CITY OF ALBUQUERQUE
PLANNING DEPARTMENT
DEVELOPMENT REVIEW BOARD

6. Project # 1002957
03DRB-01784 Major-Vacation of Public Easements

JEFF MORTENSEN & ASSOCIATES INC. agent(s) for ALBUQUERQUE PUBLIC SCHOOLS request(s) the above action(s) for all or a portion of Tract(s) 26A-1, **TAYLOR RANCH**, zoned R-T residential zone, located on TAYLOR RANCH DR NW, between MONTANO RD NW and HOMESTEAD CR NW containing approximately 14 acre(s). [REF: 03DRB-01524 & 01525] (D-11)

VACATION AND PLAT OF TRACT A, LYNDON B. JOHNSON MIDDLE SCHOOL

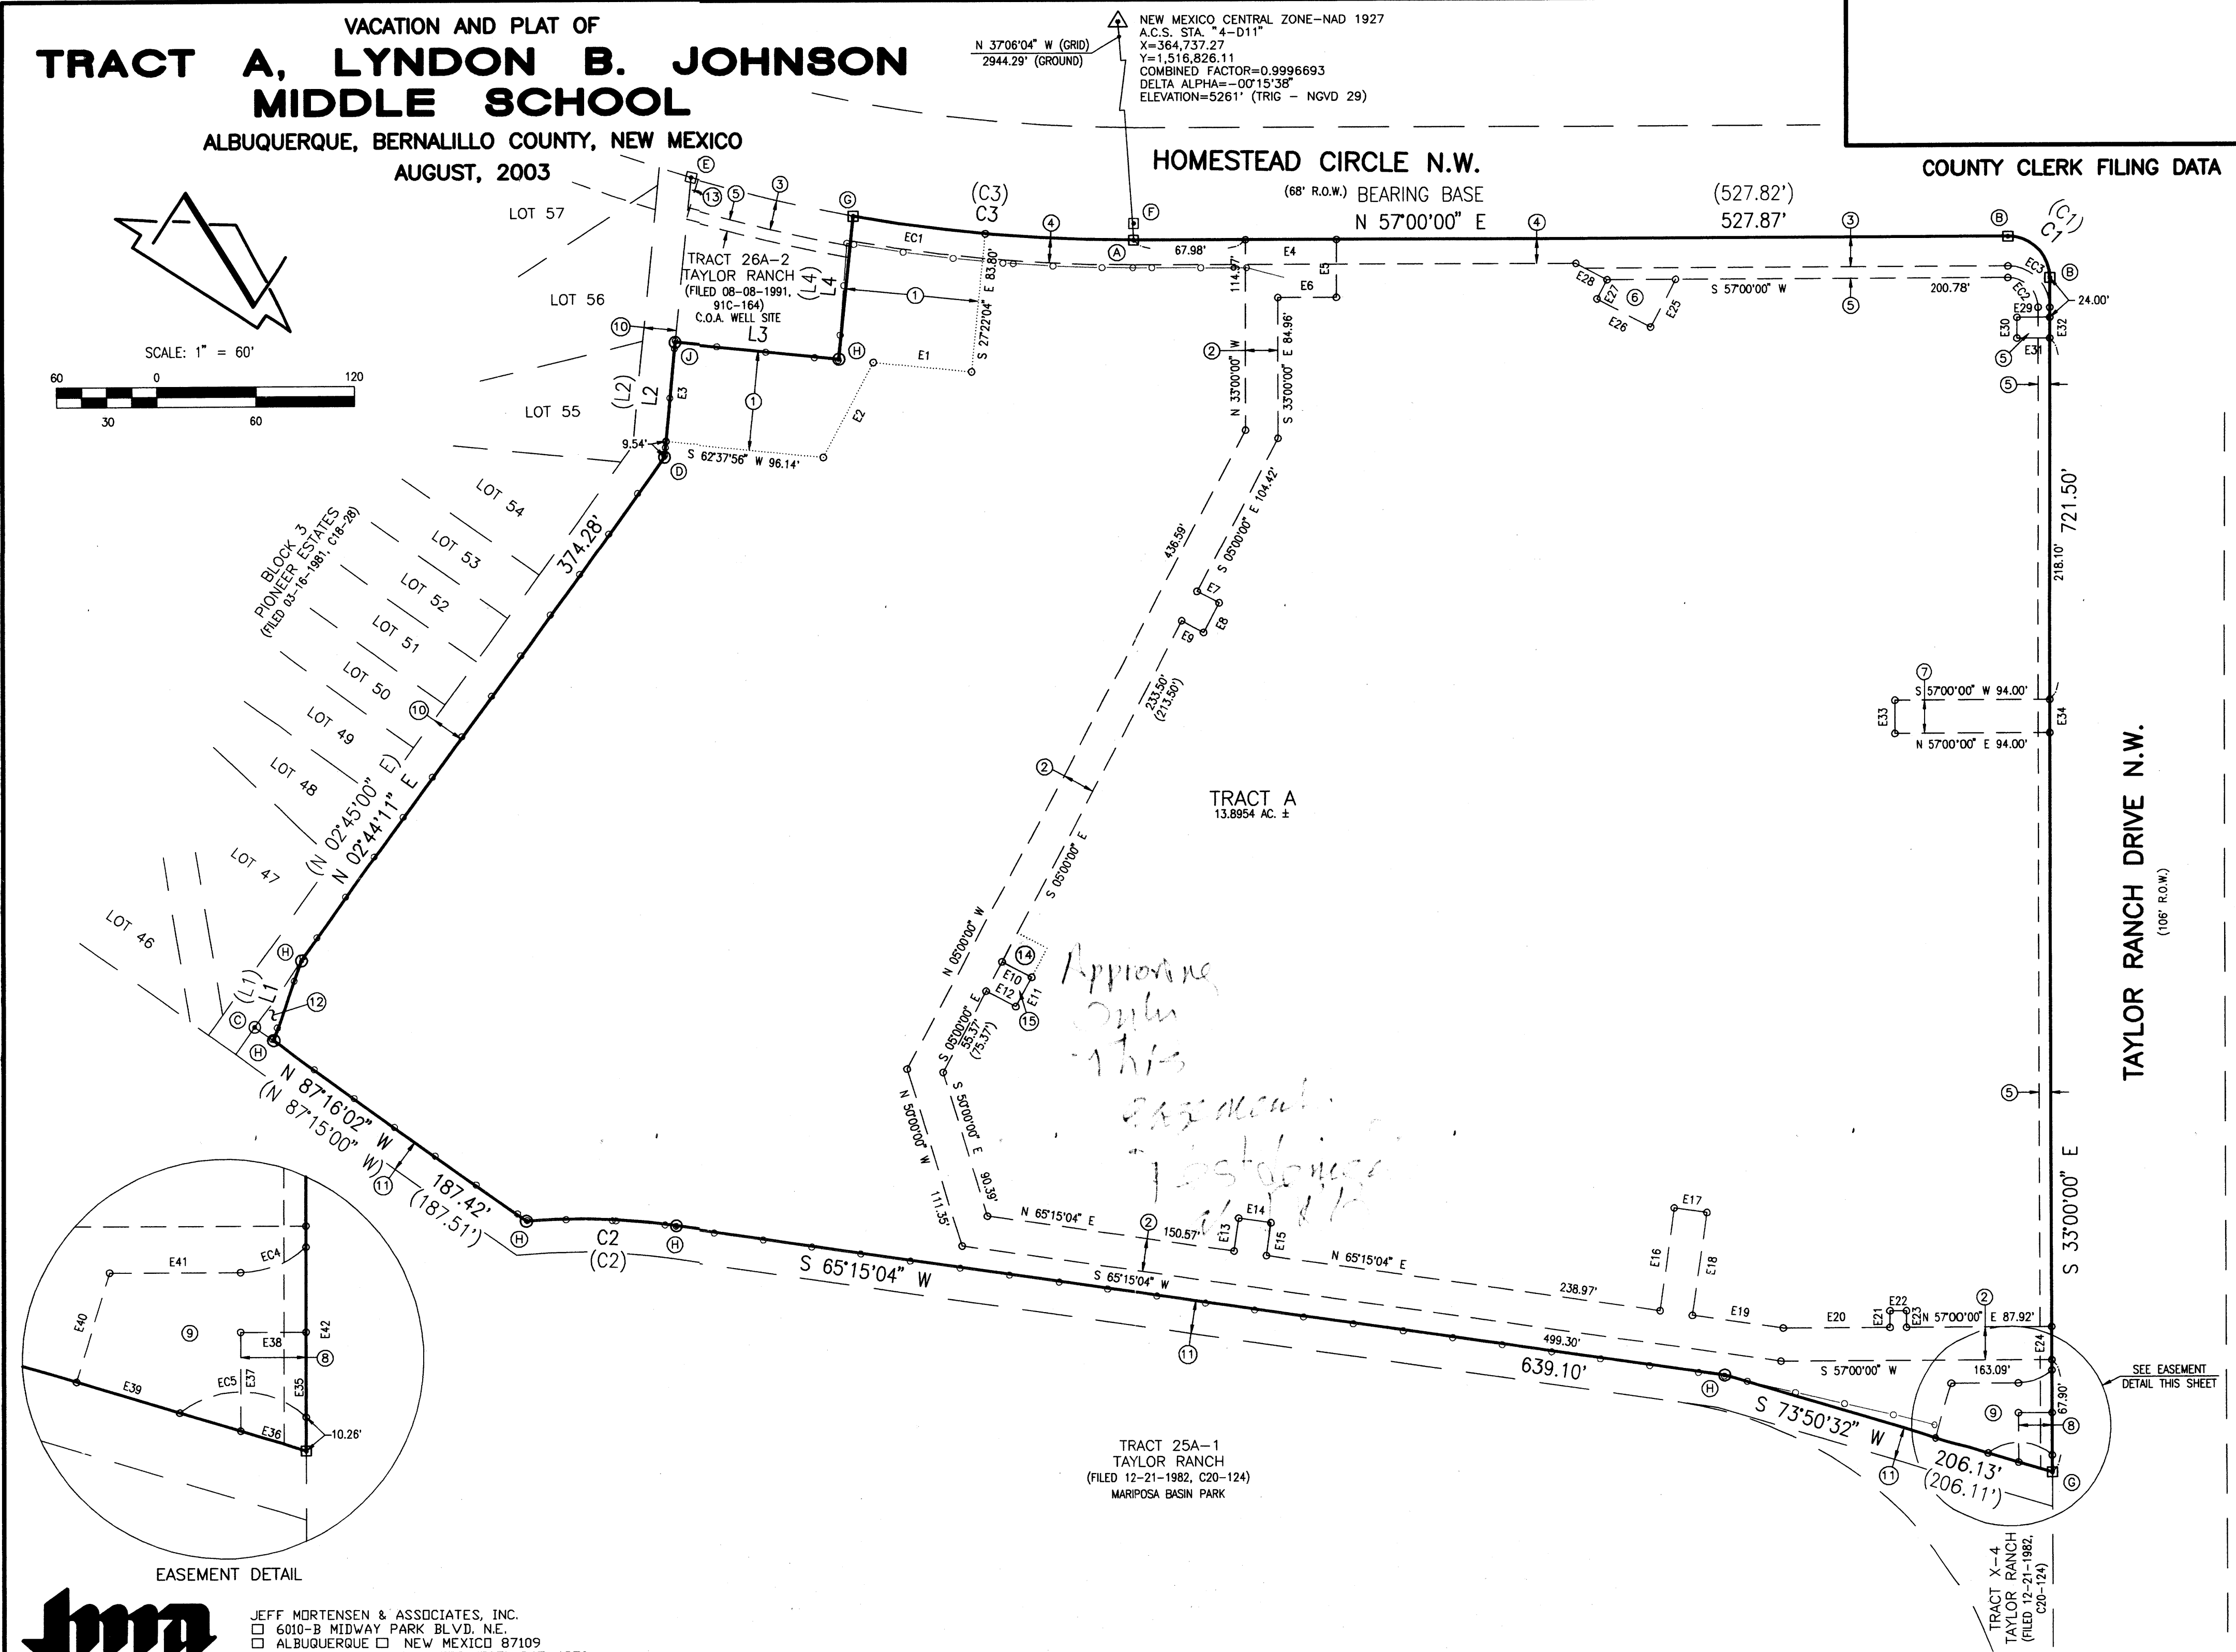
The preliminary plat was approved with final sign off delegated to Utilities Development to check for removal of vacation (1) on sheets 2 of 3 of the plat and to Planning for AGIS DXF file.

UTILITIES: Remove Vacation (1) on sheets 213 of Plat.
 Approve w/ Condition.
